Please ask for: Nicola Moore
Email: nicola.moore@arun.gov.uk
Telephone: Ext 37944
Our Ref: A/83/20/PD
Your Ref:
Date: 10th June 2020

Prior Notification for Permitted Development (Non Householder)

Development: Prior notification under Schedule 2, Part 3 Class C for part change of use from retail home and garden shop (A1) to café (A3).
Location: 1 Marsh House The Square Angmering BN16 4EA

JUNA HOME AND GARDEN
1 MARSH HOUSE
THE SQUARE
ANGMERING
WEST SUSSEX
BN16 4EA

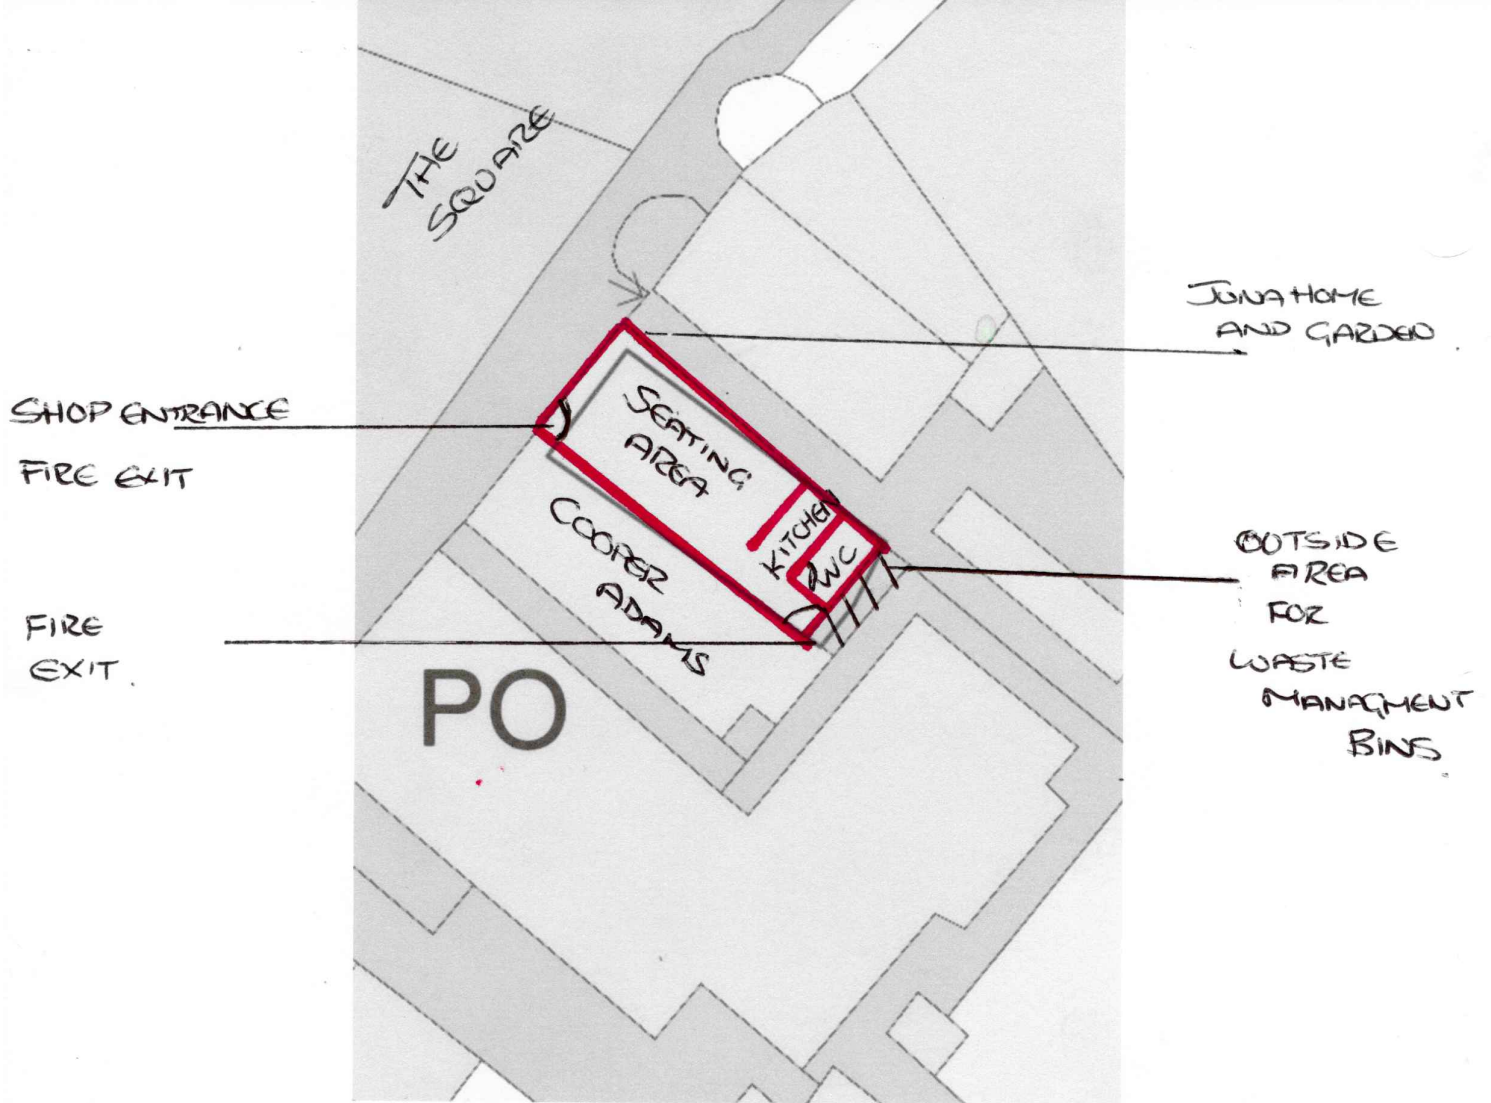
Block Plan

Please amend and re submit the Block plan to include one named road so that the site is clear. Please also clearly indicate the proposed change of use area, this can be a hatched area on the Block Plan.
